City of Portland, Maine - Building or Use Permit Application
 389 Congress Street, 04101 Tel: (207) 874-8703, Fax: (207) 874-8716

Permit No: 02-0956	Issue Date: SEP - 5 2002	CBL: CO14001
-----------------------	------------------------------------	-----------------

Past Use: Single Family	Proposed Use: Single Family / Add 550 sq. ft. Deck on rear of house.	Permit Fee: \$135.00	Cost of Work: \$16,000.00	CEO District: 2
Proposed Project Description: Add 550 sq. ft. Deck on rear of house		FIRE DEPT: <input type="checkbox"/> Approved <input type="checkbox"/> Denied INSPECTION: Use Group: R-3 Type: 5B BOCA 1999 Signature: <i>AMB 7/5/02</i>

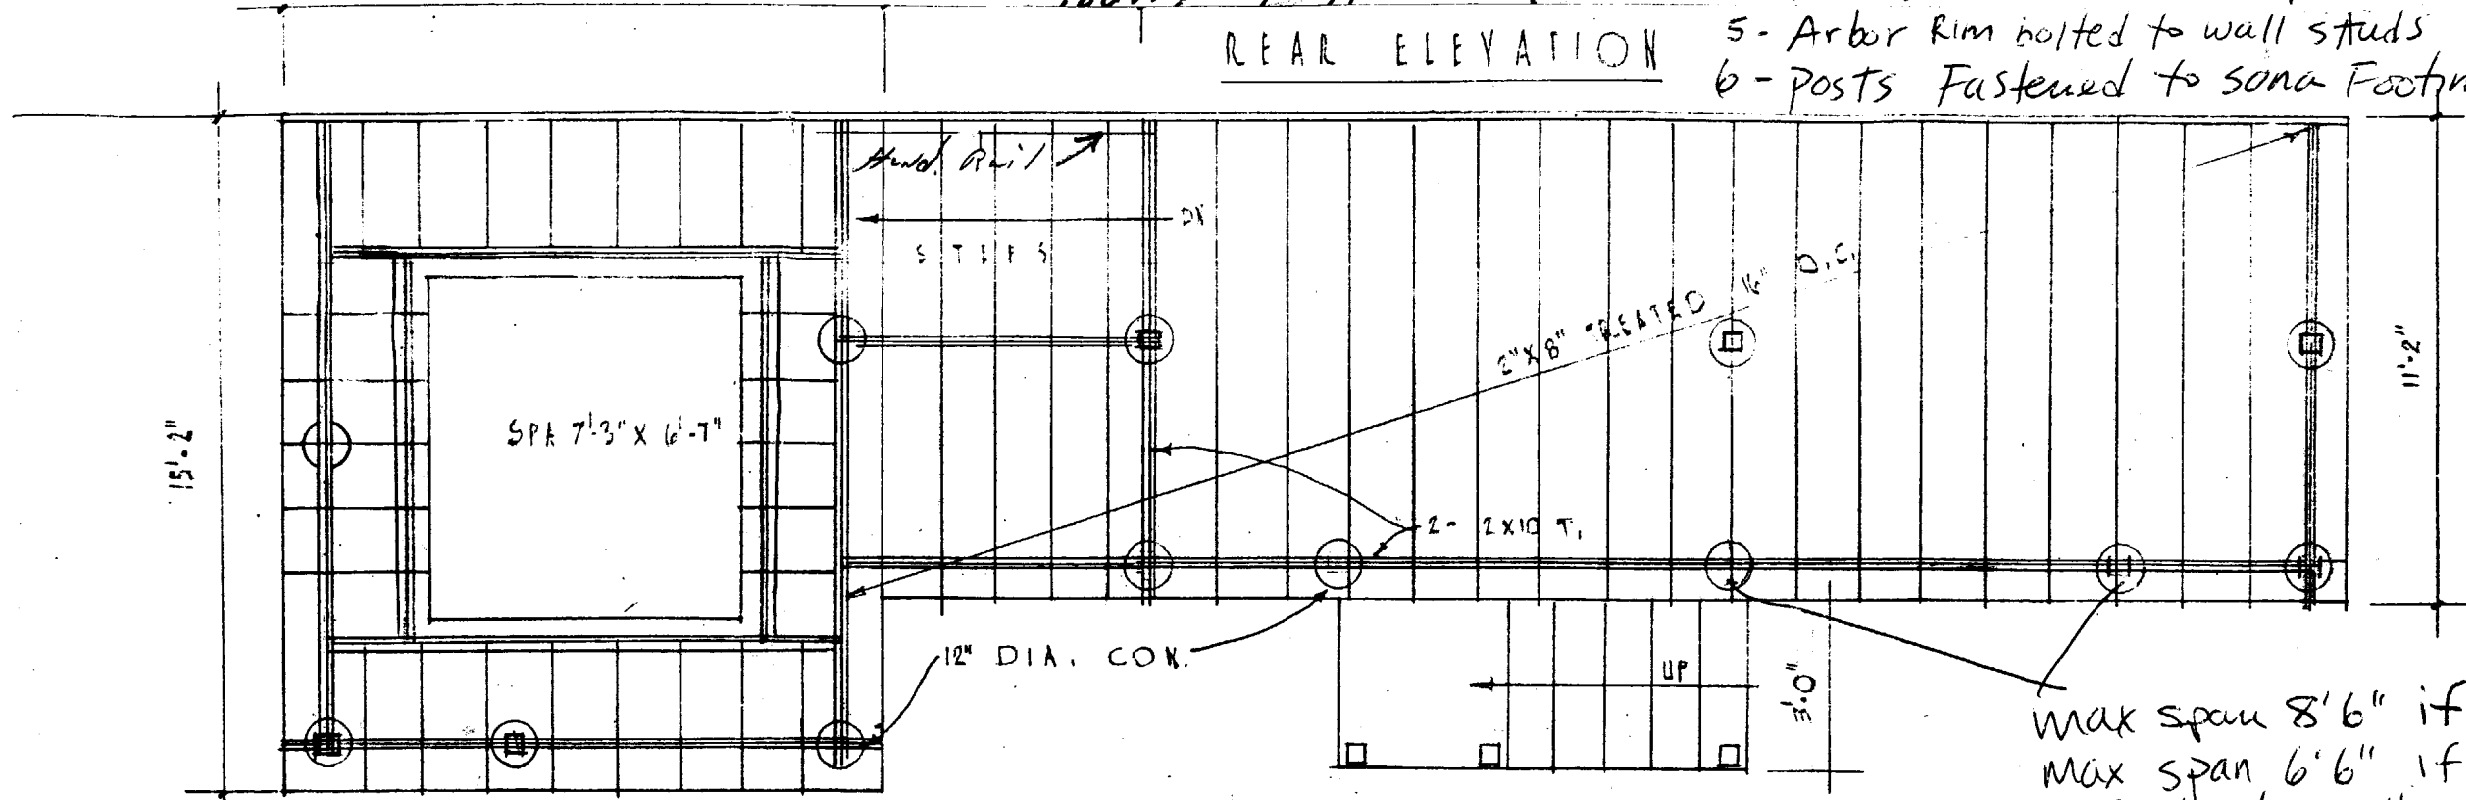
8/29/02 R-2 zone - only showing 10' side setback where 12' is required - I called Greg Plimpton as shown on the application and left a message - talked to contractor, he revised plans and will be 12' from the side property line.

It is understood thru a conversation with the contractor that there shall be a 12' side yard setback on the left side of this deck which complies with the R-2 zoning requirements. All setbacks are measured to property lines. The Code Enforcement Officer shall be checking the setbacks PRIOR to the placing of any concrete.

8/29/02
 side setback
 will be 12' per
 Greg Plympton The
 CONTRACTOR
 DRIVE

FRAMING PLAN

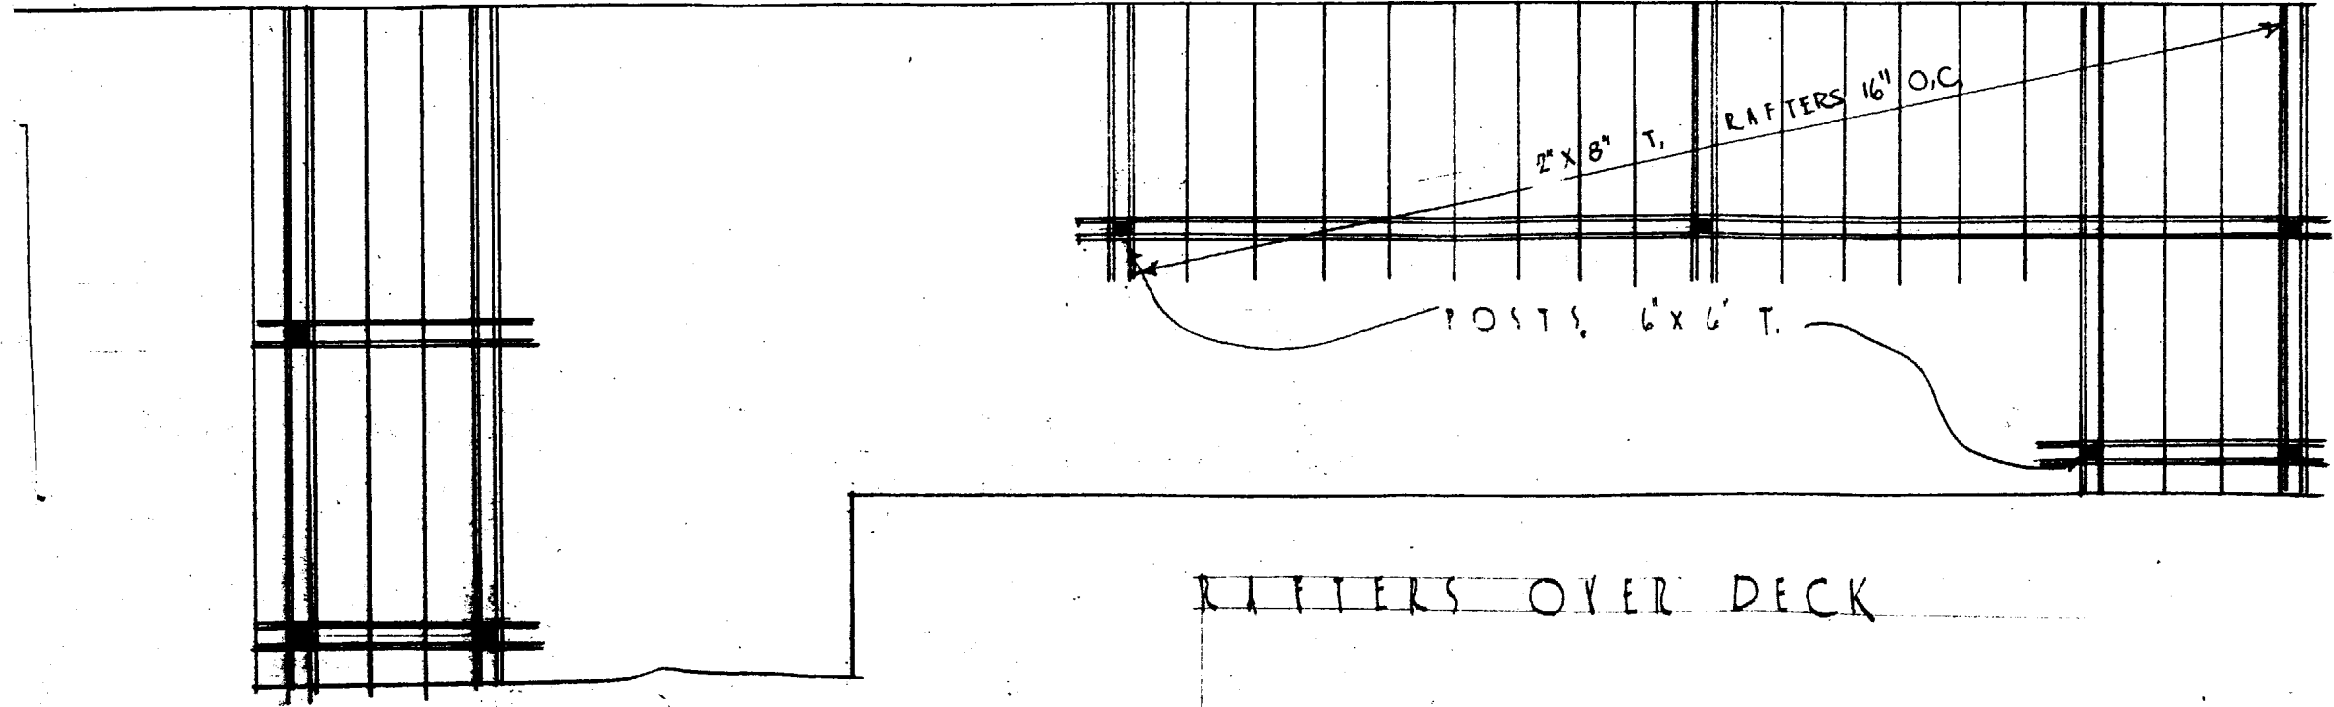
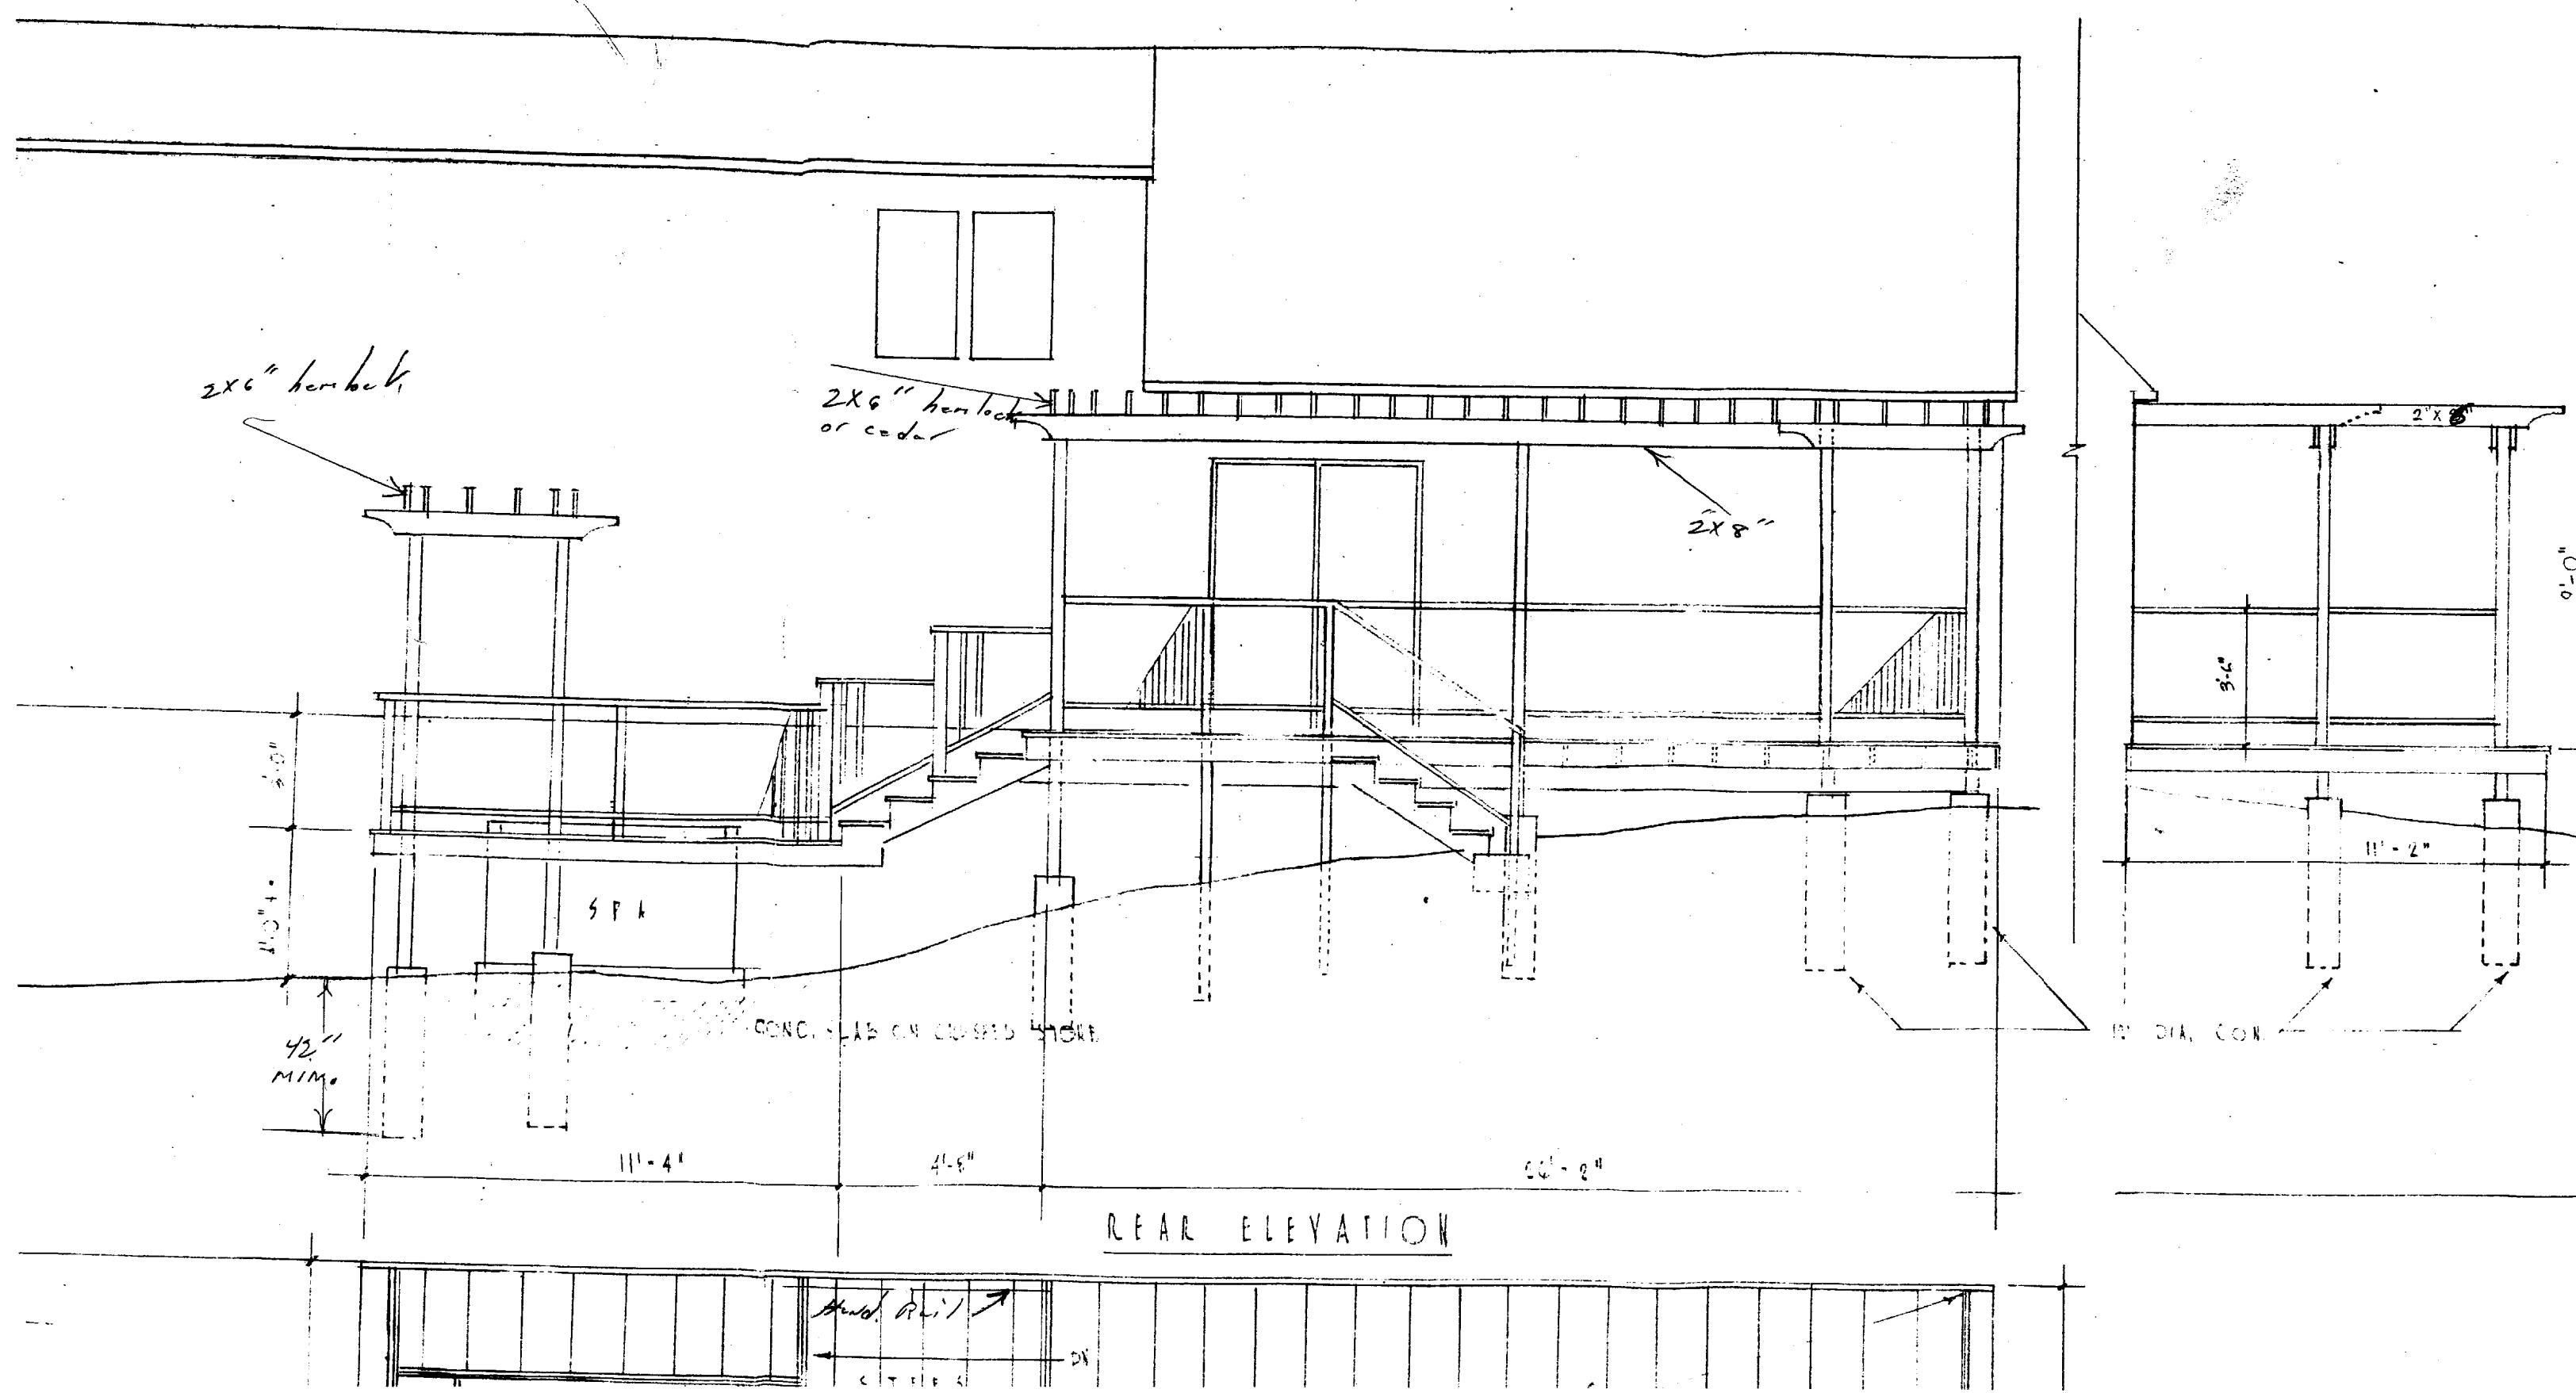
- 1 - All footings to be 48" depth or to ledge
- 2 - Rim ledger brackets bolted thru foundation
- 3 - Joist hangers installed at all non-bearing points
- 4 - Headers and beams around spa cut out to be doubled
- 5 - Arbor rim to be bolted to wall studs
- 6 - Posts or girders to be fastened to sona footings
- 7 - Guardrail system to meet BOCA '99 Sec. 1021

Contractor will adjust footing spacing on site for girder support.
Max span if using 2-2X10 = 8' 6"
Max span if using 2-2X8 = 6' 6"
